**Consultation Response KC Landscape**

<b>Planning Number:</b>	2025/93229		
<b>Proposal:</b>	Discharge of details reserved by conditions 15 (drainage), 33 (waste), 37 (cycle parking), 41 (LEAP) on previous permission 2021/93567 for demolition of existing commercial buildings and erection of 180 dwellings with associated works		
<b>Location:</b>	Land off, Westgate, Cleckheaton, BD19 5DR		
<b>DEVELOPER/APPLICANT/AGENT:</b>	<b>Strata</b>		
<b>Planning Officer:</b>	Farzana Tabasum		
<b>Date Responded:</b>	09.03.2026	<b>Responding Officer:</b>	EM
<b>Site Area (Hectares)</b>		<b>Responding Ref:</b>	<b>PP75</b>

**NOTES/COMMENTS: COND 41 LEAP:**

SHEET TITLE: **LEAP**

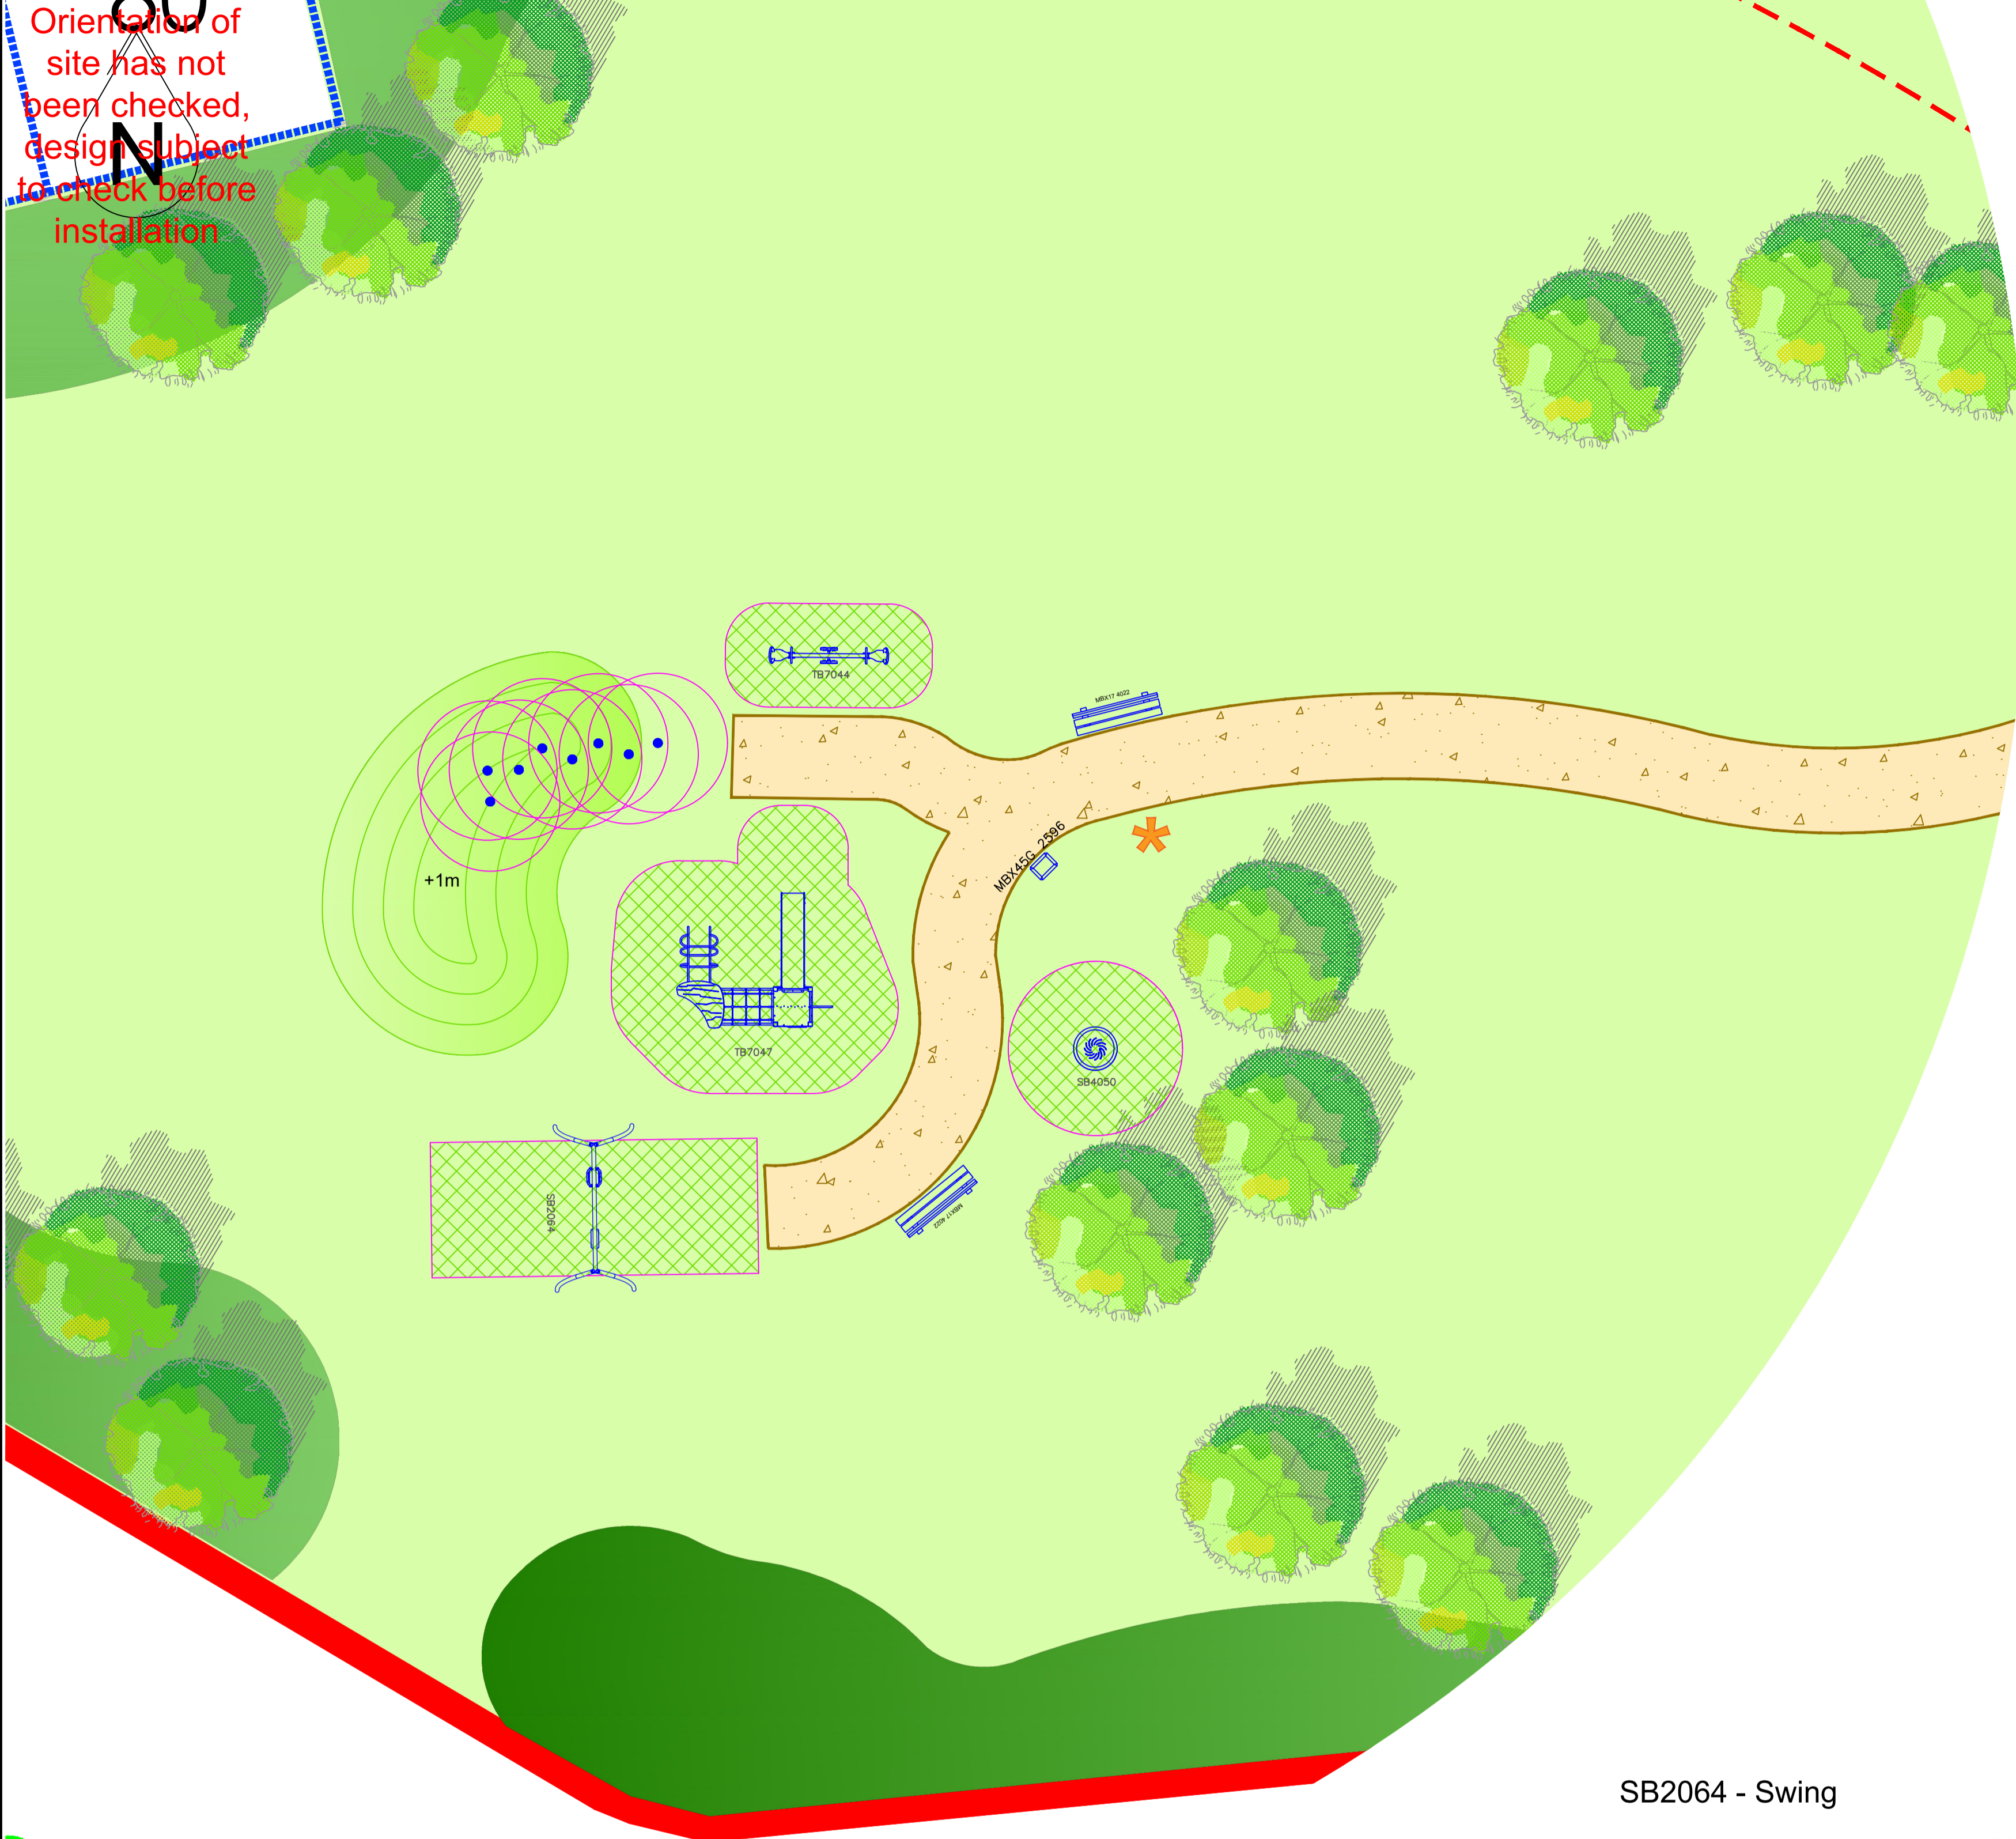
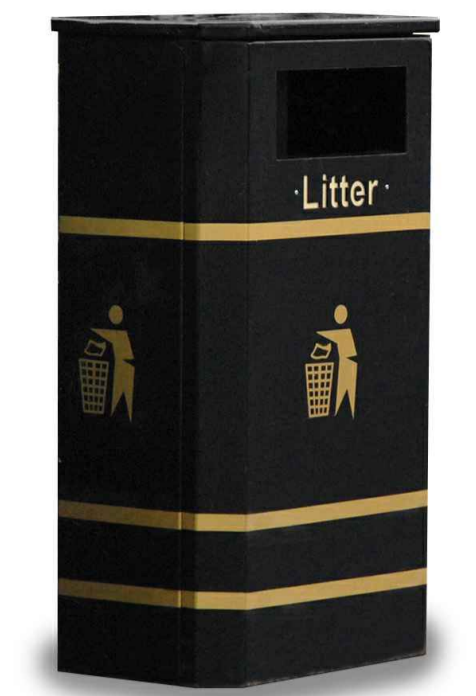
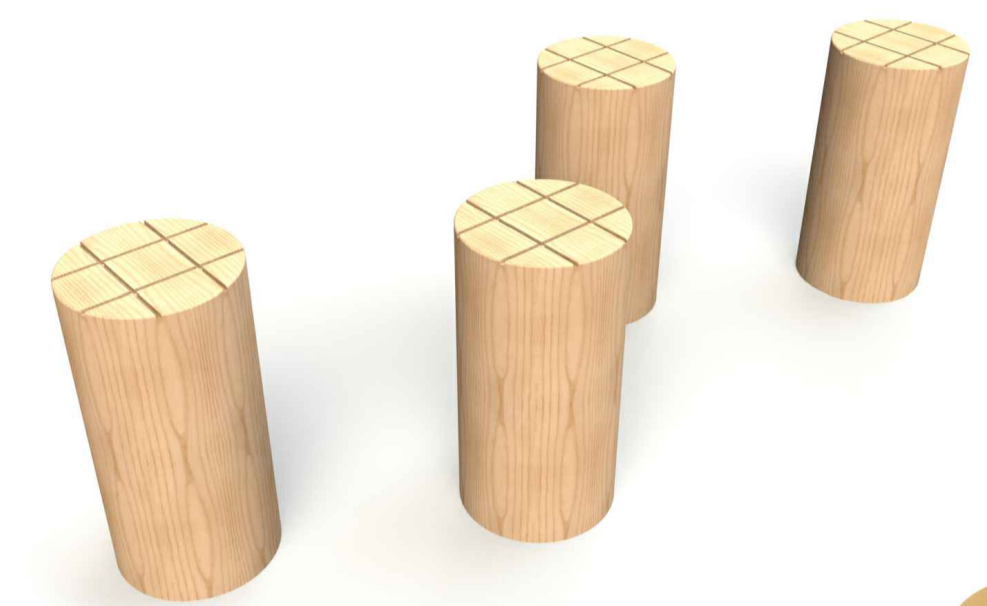
Our previous comment in December 2025 raised concern about the slide orientation, specifically the north-facing slides, (which are more prone to dew, frost, and slower drying) the developer has since confirmed they are not rotating the slides. This was not a specific requirement in the condition.

1. If the climbing frame unit were pivoted clockwise 90 degrees to face east (rather than north), both the slides would benefit from early sun exposure from the east, helping them dry out sooner without their metal surfaces overheating in the midday or afternoon sun (so don't face them south).

With that aside, the matters listed in the condition are therefore accepted as resolved/confirmed and provided all the landscape measures specified for the LEAP and on the LEAP Drawing issue A ref : Q11701\_A are incorporated and maintained as outlined hereafter, **we would support the discharge of Condition 41 LEAP.**
